**CONDITIONS OF APPROVAL - Project # PR-2025-011387/SI-2025-00040 - Site Plan-EPC**

The purpose of this letter is to demonstrate how the Site Plan-EPC for Savio Ridge was revised to meet the Environmental Planning Commission's (EPC) conditions of approval per the hearing held on March 20, 2025 (Project # PR-2025-011387/SI-2025-00040).

LPN-1 7 of 21

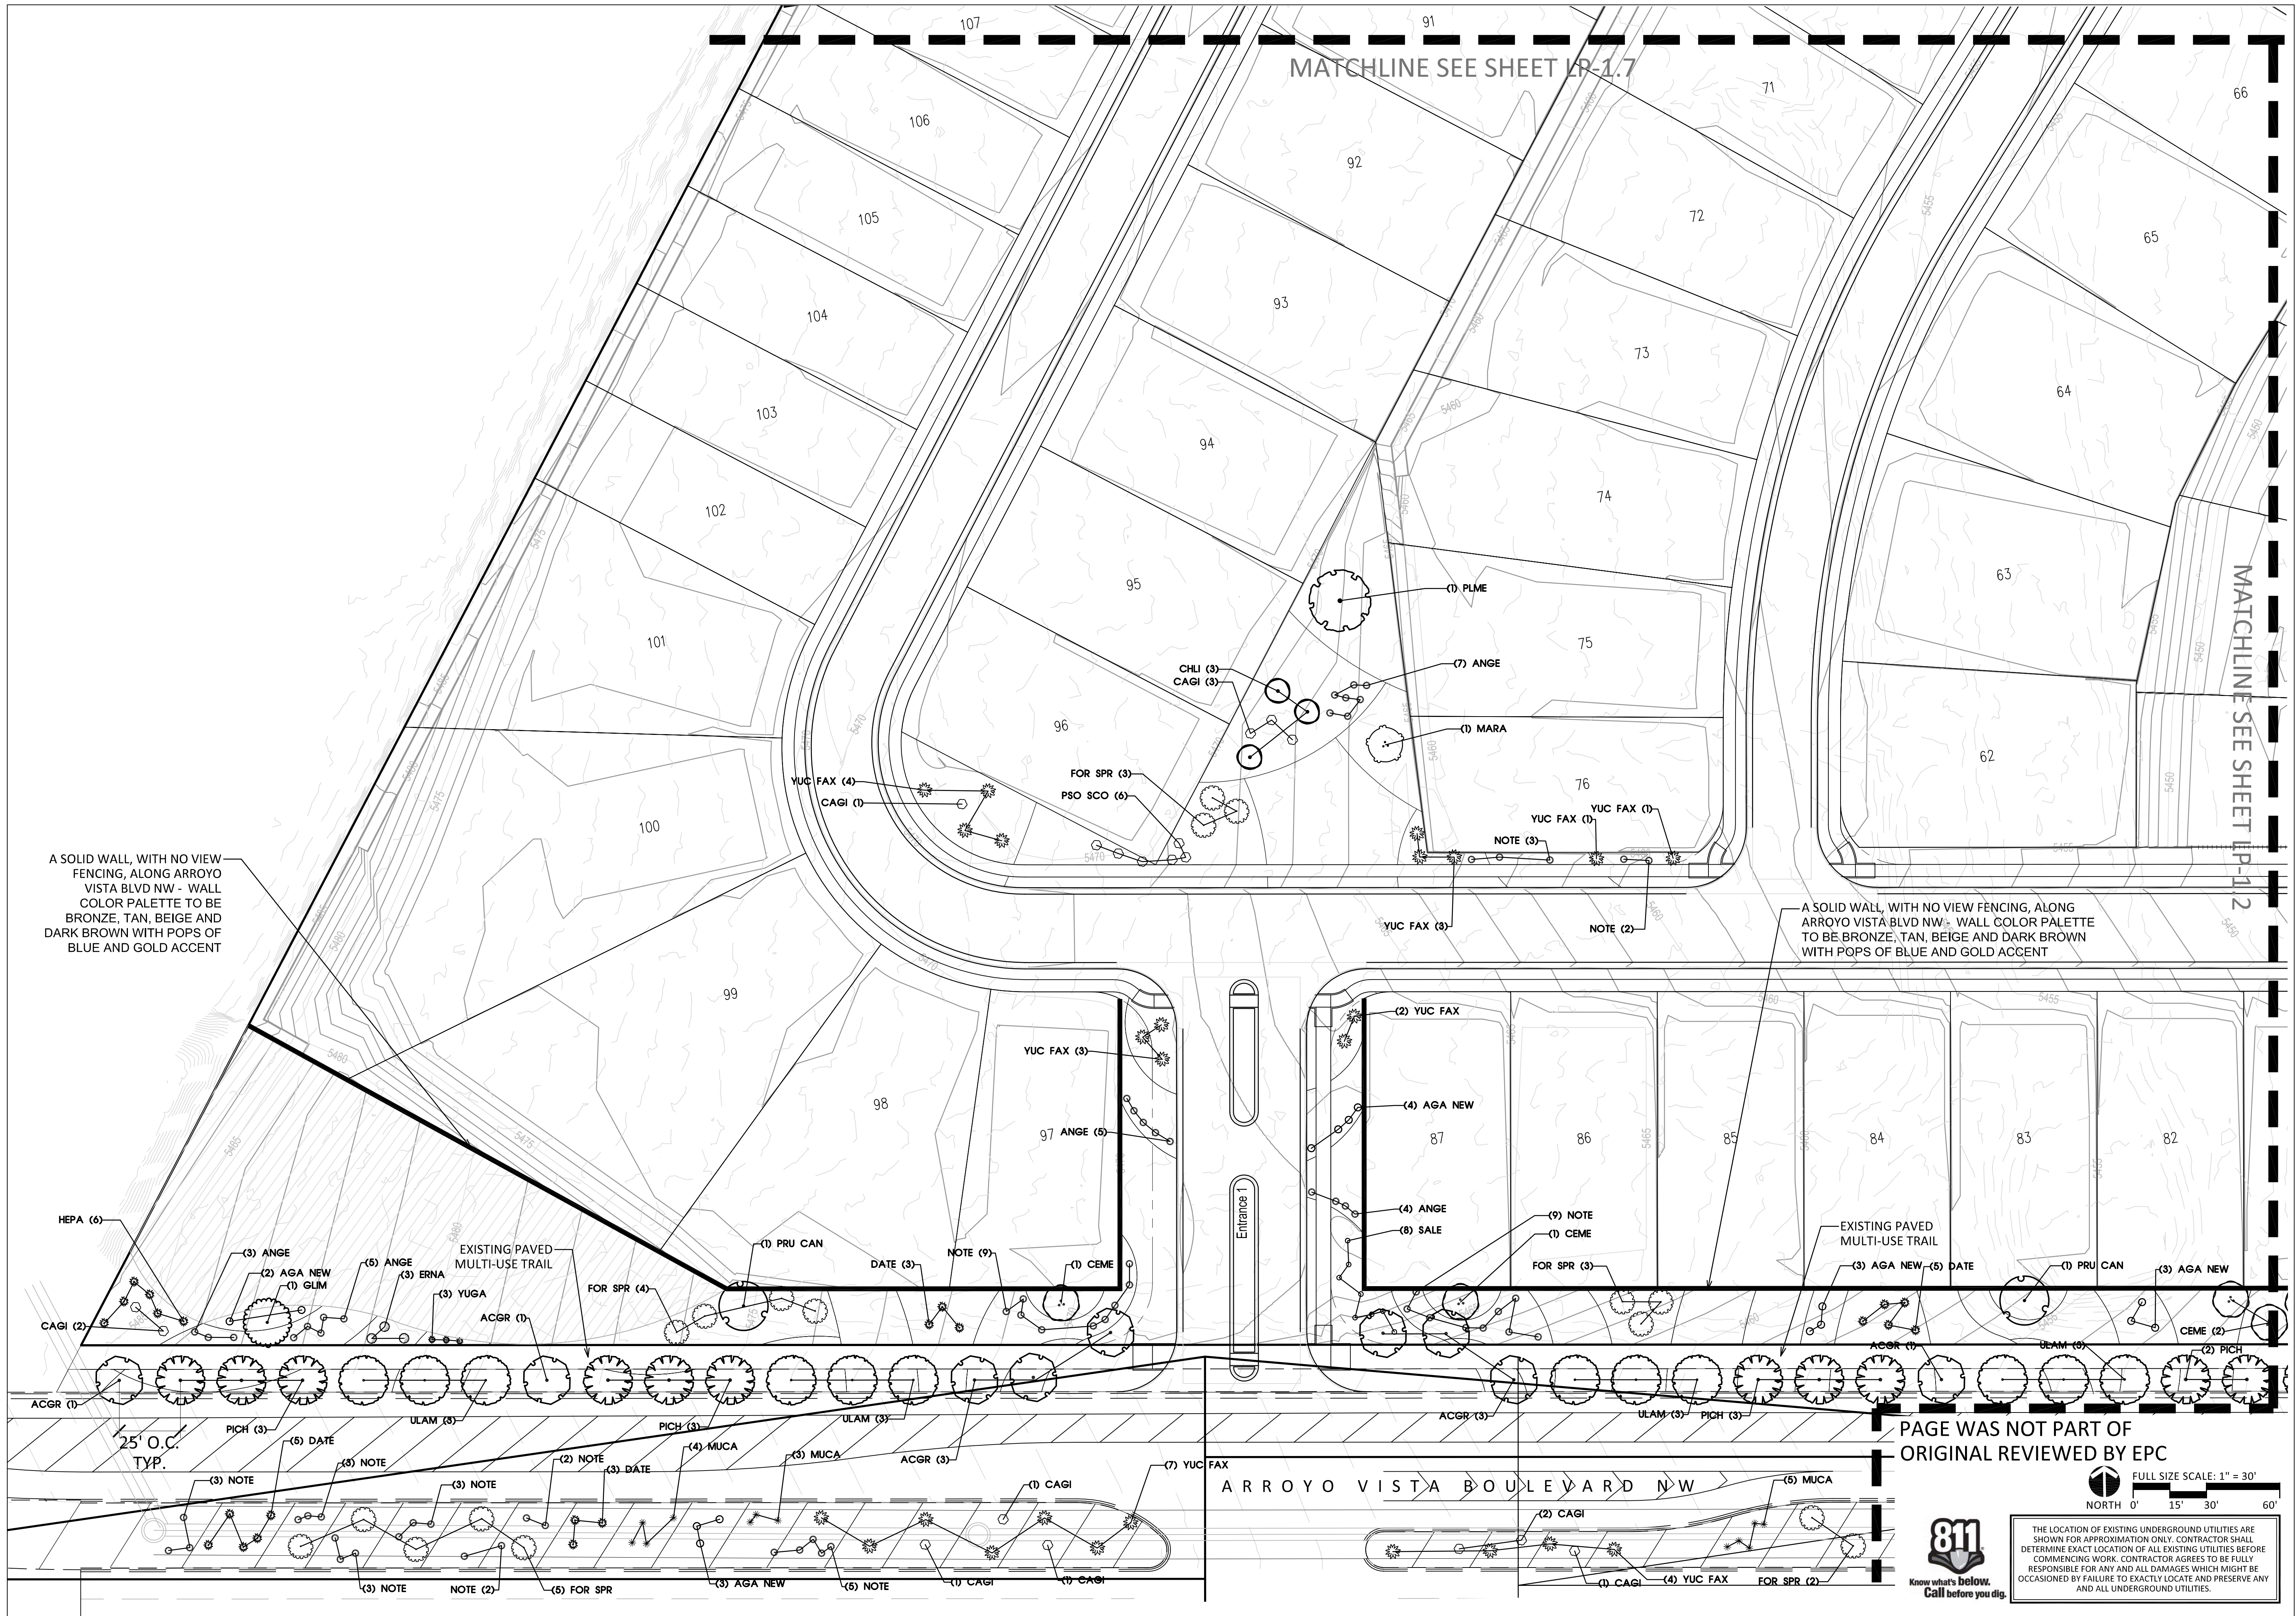
- a. An updated landscape plan shall be provided which depicts one street tree per lot or a general note shall be provided which states that this requirement will be met.

- a. A detail of the fencing adjacent to the open space requested by the National Park Service and the wall adjacent to the ABQ Public School shall be provided that notes: perimeter walls adjacent to the open space and APS to be constructed with a lower CMU portion and view fencing on top. The applicant shall work with the National Parks Service on finalizing fence design details along the Monument boundary.

- b. A solid wall with no view fencing along Arroyo Vista Blvd NW shall also be noted.

- c. For the perimeter wall, a note shall be added that matches the color pallet of the entry gate wall: "overall color palette to be bronze, tan, beige and dark brown with pops of blue and gold accents."

*Applicant Response: A general note has been added that addresses this requirement. See sheet LPN-1.*

*Applicant Response: A note has been added to the sheet LPN-1 (Wall Notes A). Perimeter fencing adjacent to the petroglyph national monument boundary shall be 5'-6' steel wire mesh (hog wire) on wooden posts as approved by the National Park Service to match the existing fence to the west, adjacent to the Inspiration subdivision.*

*Applicant Response: A note has been added to the sheet LPN-1 (Wall Notes B).*

*Applicant Response: A note has been added to the sheet LPN-1 (Wall Notes C).*

GENERAL NOTES

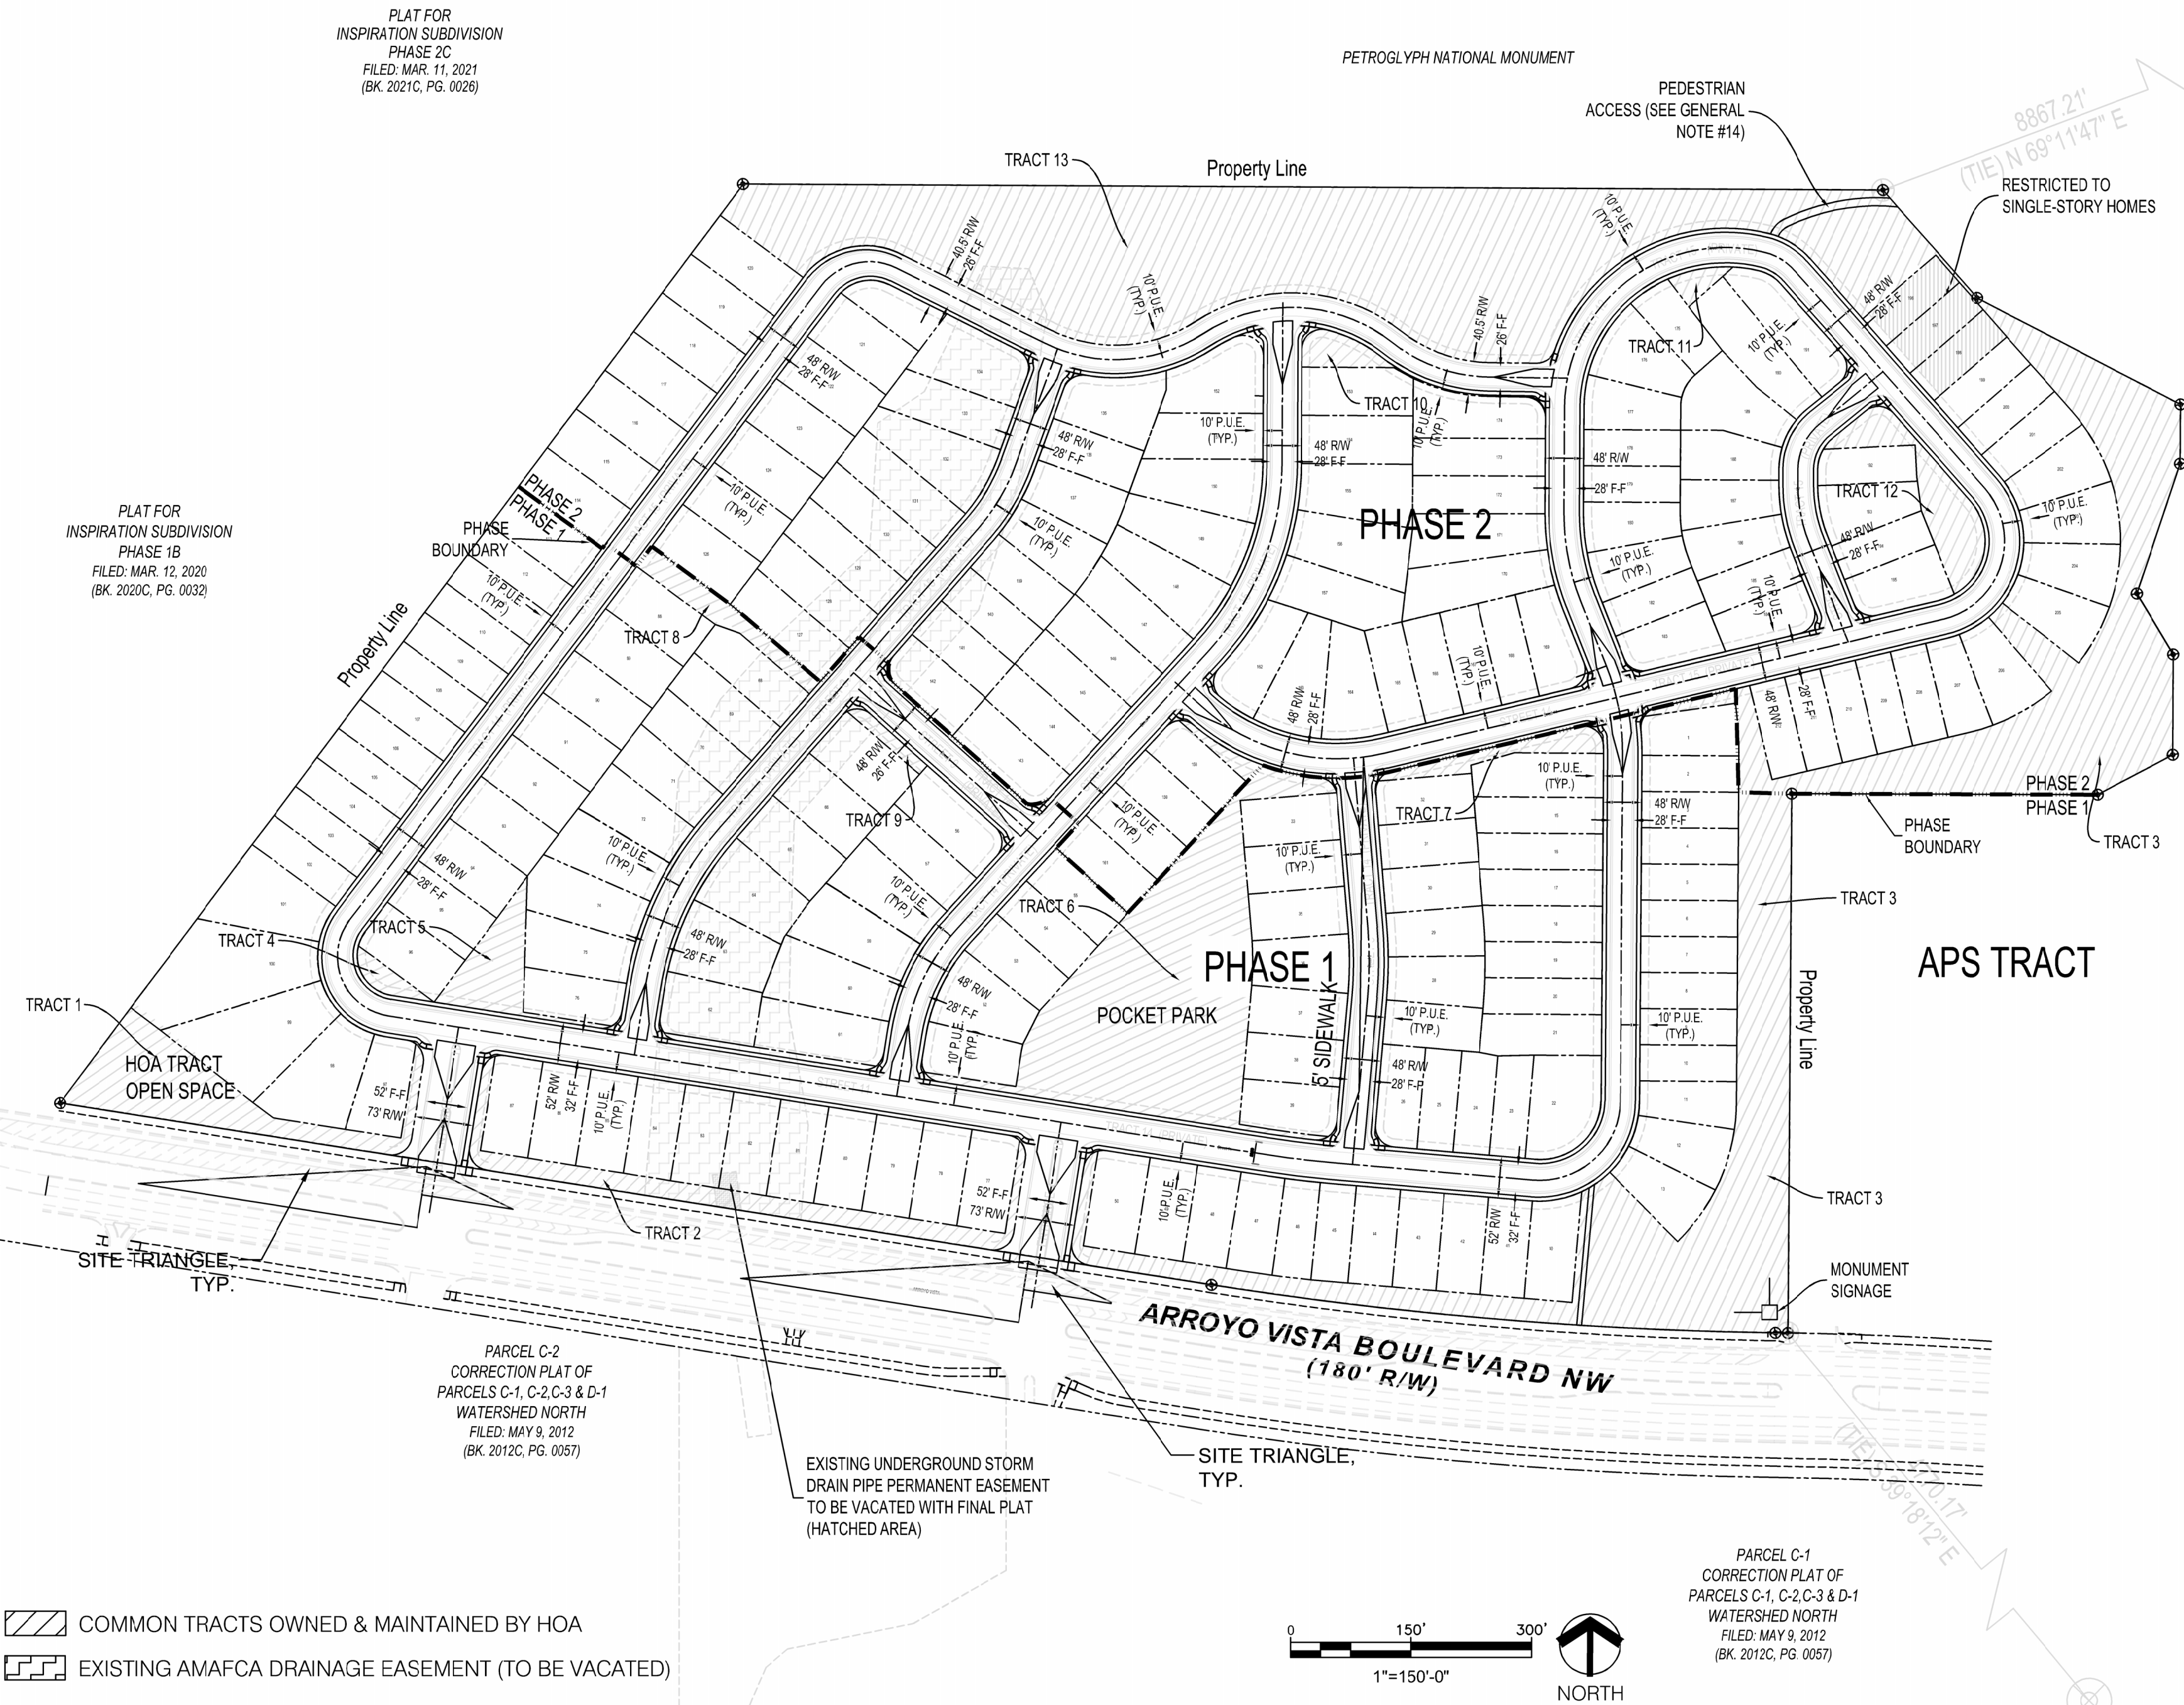
4. The DHO shall review the associated Bulk Land Platting action (PR-2024-010189) upon final sign off of this request. The location of the eastern property line on the Site Plan EPC shall coincide with the bulk land plat reviewed and decided by the DHO following approval of this Site Plan EPC, as noted on the site plan.

- 9. The Site Vicinity Map shall be updated on the site plan to include the full 110-acre site.

11. The developer and general contractors shall clean up debris from the construction of the single-family residential lots and homes daily, remove it from the construction site, and use covered trash containers (and close the lids). The developer will provide an on-call contractor for the National Parks Service to contact for debris clean up on the Petroglyph National Monument Property. The developers will monitor contractors frequently to ensure they are complying with these stipulations to protect the Petroglyph National Monument and sensitive lands adjacent to and on the subject site.

*Applicant Response: The DHO approved the Bulk Plat (PR-2024-010189) on April 9, 2025 (see attached Notice of Decision), and a note was added to Sheet 1 reflecting that approval. The property line for the Site Plan – EPC reflects the approved property line.*

*Applicant Response: See updated Sheet 1.*

*Applicant Response: See new General Note #15 on Sheet 1.*
